KITTITAS COUNTY COMMUNITY DEVELOPMENT SERVICES

August 11, 2014

Subject: Cowger Boundary Line Adjustment (BL-14-00018)

BOUNDARY LINE ADJUSTMENT EXHIBIT
 BETWEEN
 LOT 12-22, PHASE 3, DIV. 12, SUNCADIA (TUMBLE CREEK)
 AND
 TRACT OS-9, PHASE 3, DIV. 11, SUNCADIA (TUMBLE CREEK)

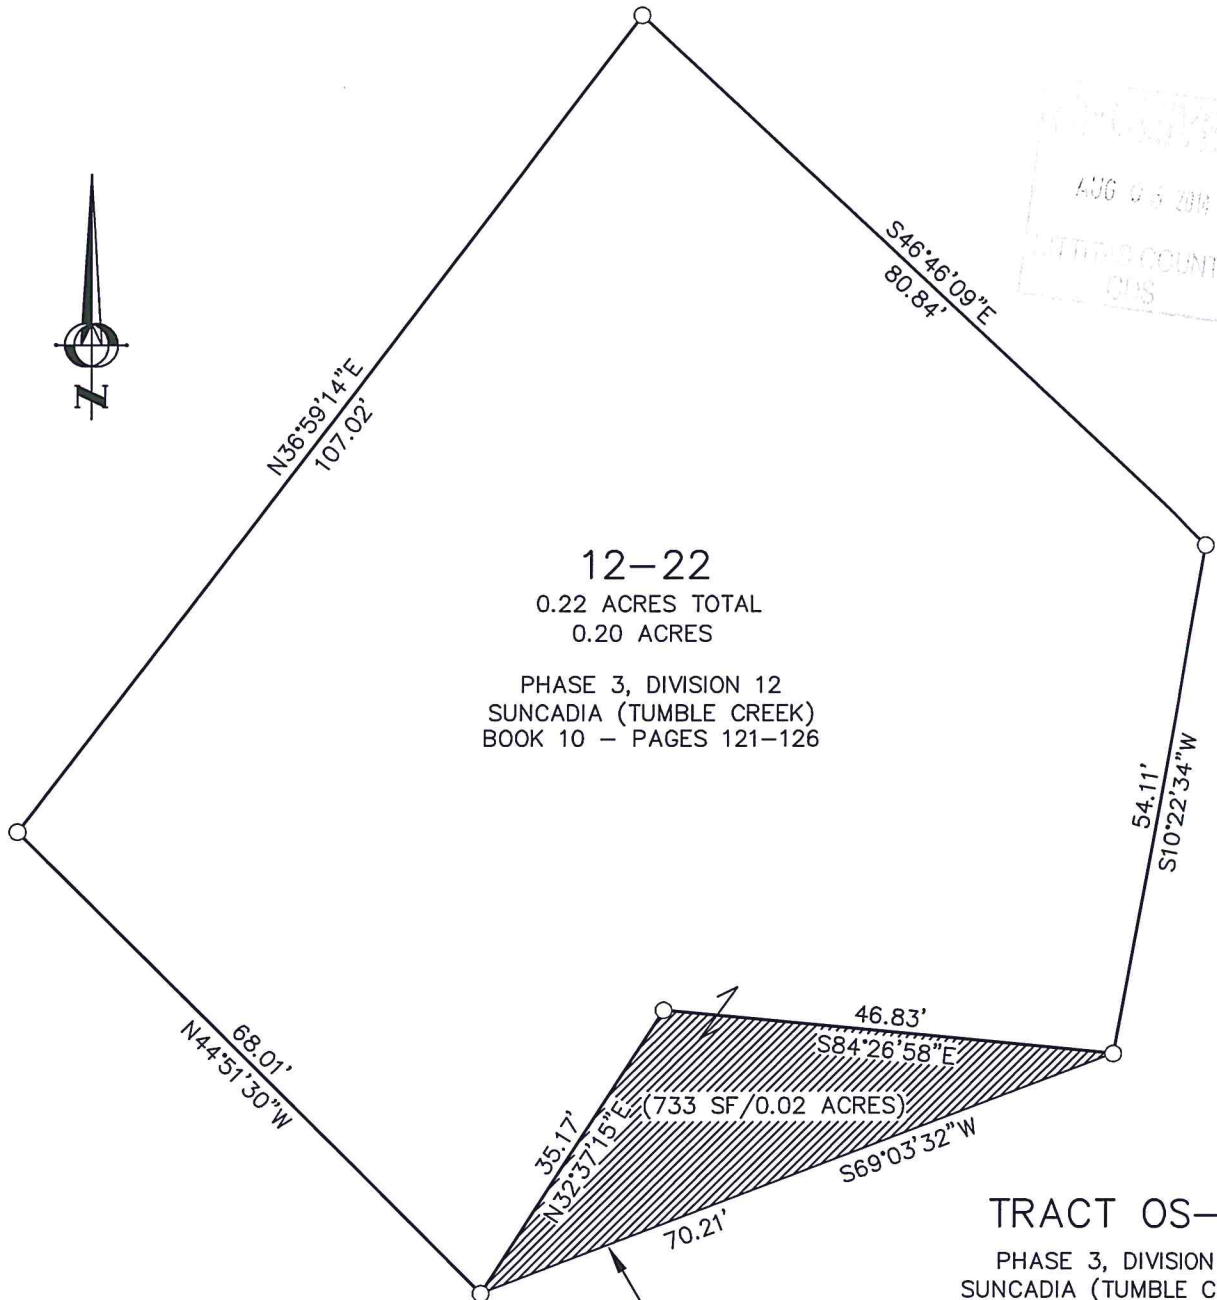
Community Development Services is in receipt of the referenced application. This application has been deemed **incomplete** due to the fact that Kittitas County Community Development Services must follow the development agreement and all supplemental information associated with the approved Plat. The plat application for Phase 3 Division 12 states that there will be 50.4% open space in the Plat. Therefore the additional information is needed:

- Proof that all open space is maintained (50.4%). *All subject parcels must be contiguous for a Boundary Line Adjustment.*

- Plat Amendment changing the parcel configuration/ setbacks to allow for the construction, but maintaining the original amount of open space. *All property owners associated with the plat will need to sign off in approval of the Plat Amendment.*
